**DEVIATION REQUEST  
AND DECISION FORM IN  
ASSOCIATION WITH A  
REQUEST FOR A PUD  
MODIFICATION FROM  
THE ECM**

A deviation from the standards of or in Section **ECM2.2.4.B.7 (Figure 2-17), Table 2-7** of the Engineering Criteria Manual (ECM) is requested.

**WATERSIDE TOWNHOMES**  
 DEVIATION REQUEST - ECM SEC. 2.2.4.B.7.  
 FIGURE 2-17, TABLE 2-7  
 PCD FILE NO. PUDSP-22-009

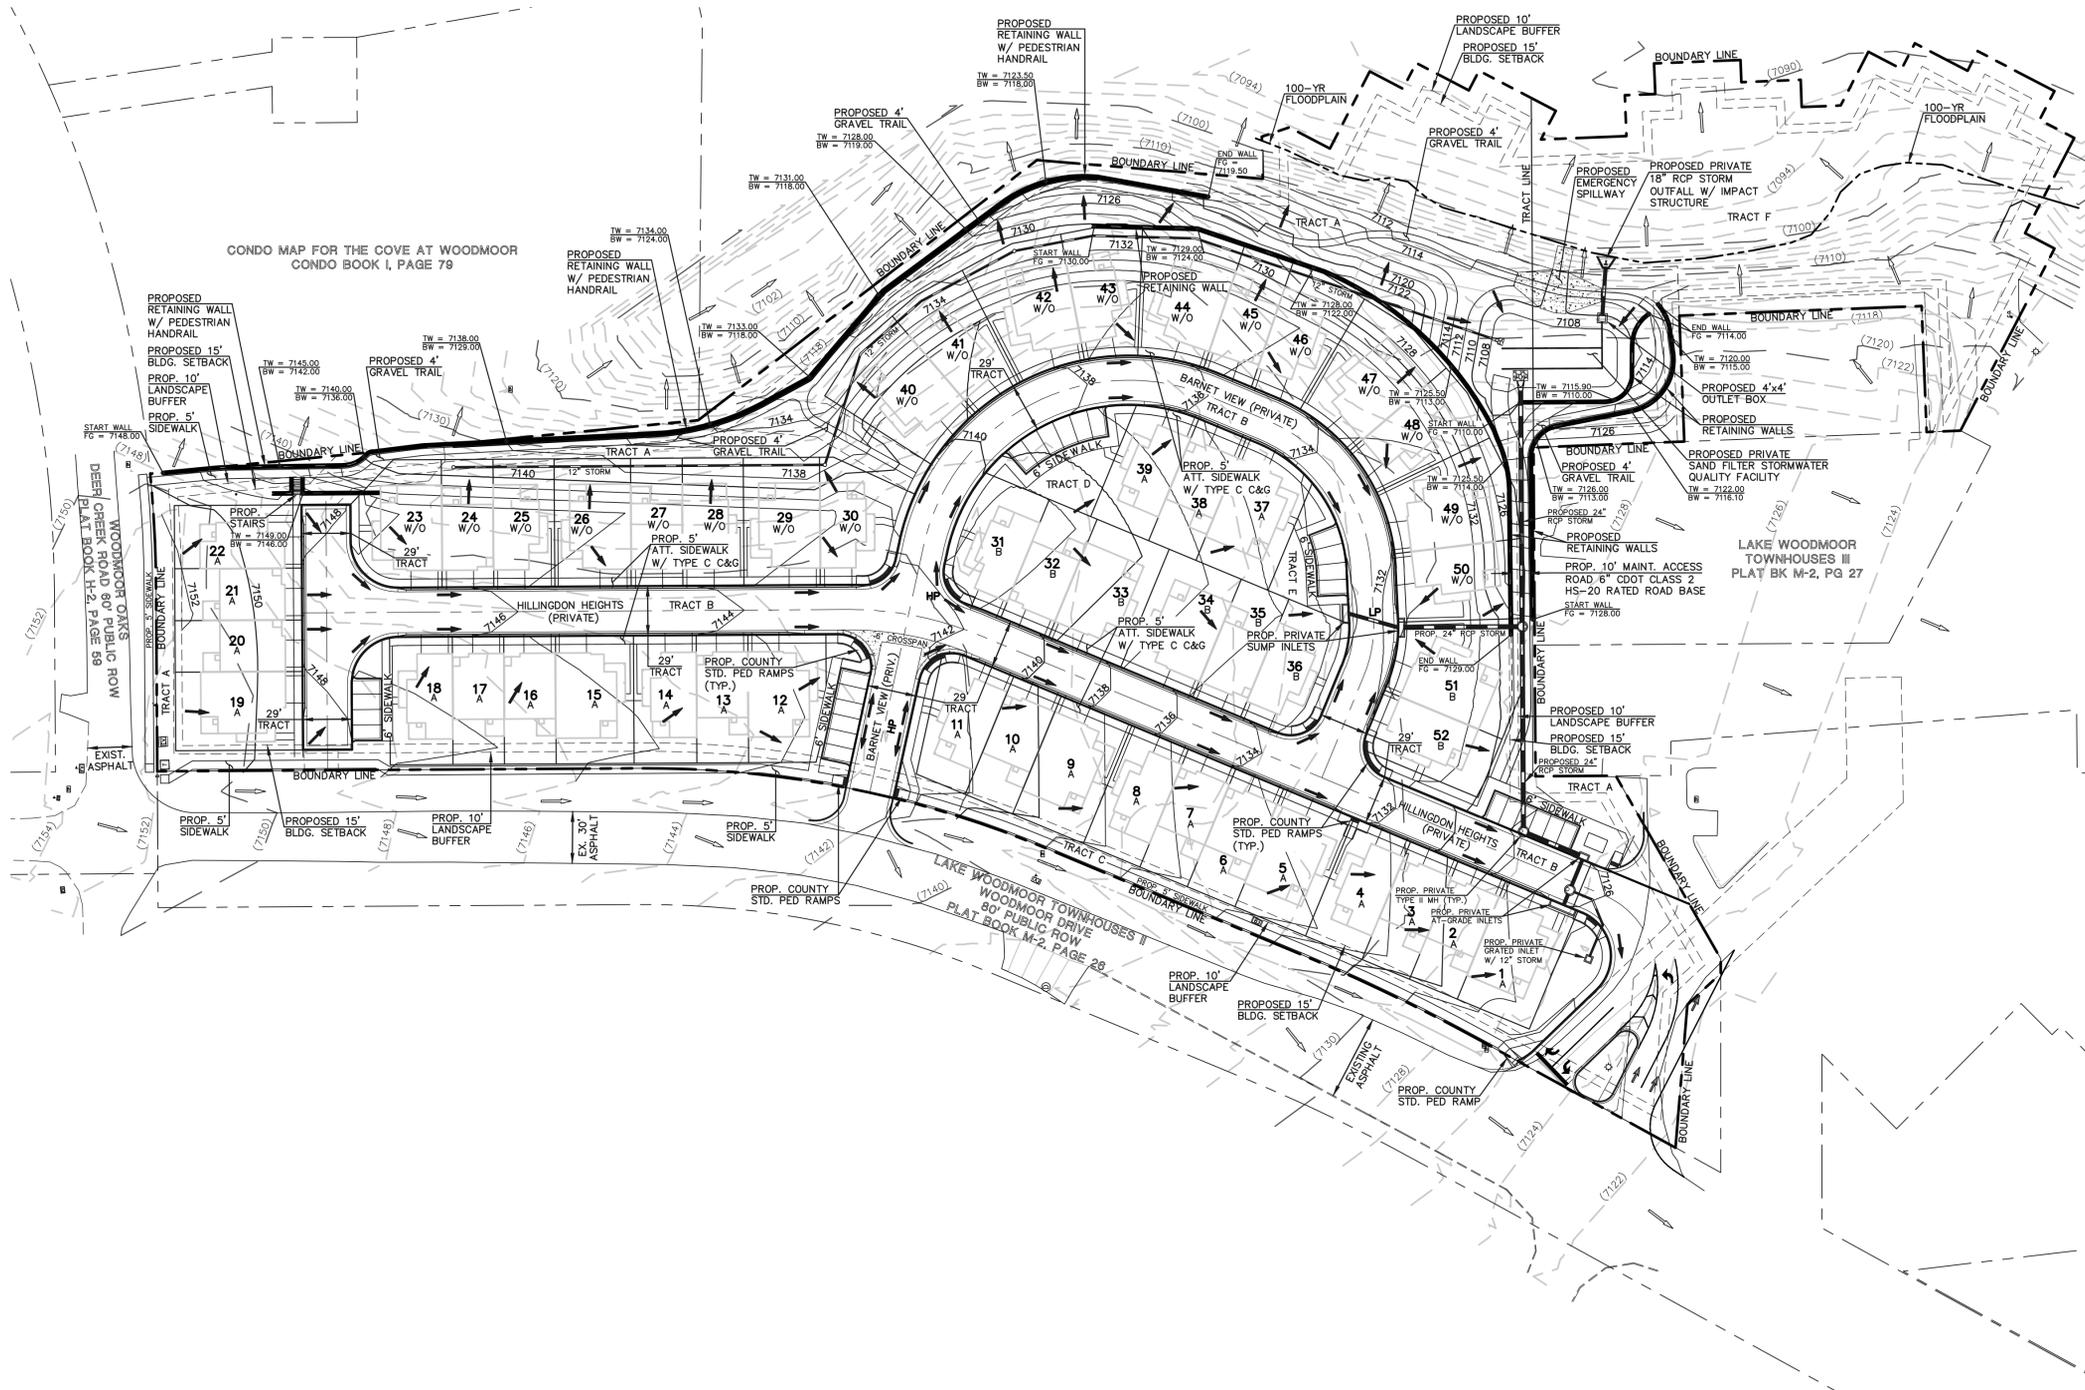
Add deviation request for tangent length for broken back curves and pavement width into this request. Local low volume road still needs to meet tangent length for a local road and the local road portions need the deviation from a standard 30' wide asphalt mat. ECM administration designee has no issues with the proposed deviations, they just need to be properly documented within the project file. If there are additional questions in regards to this, please let reach out.
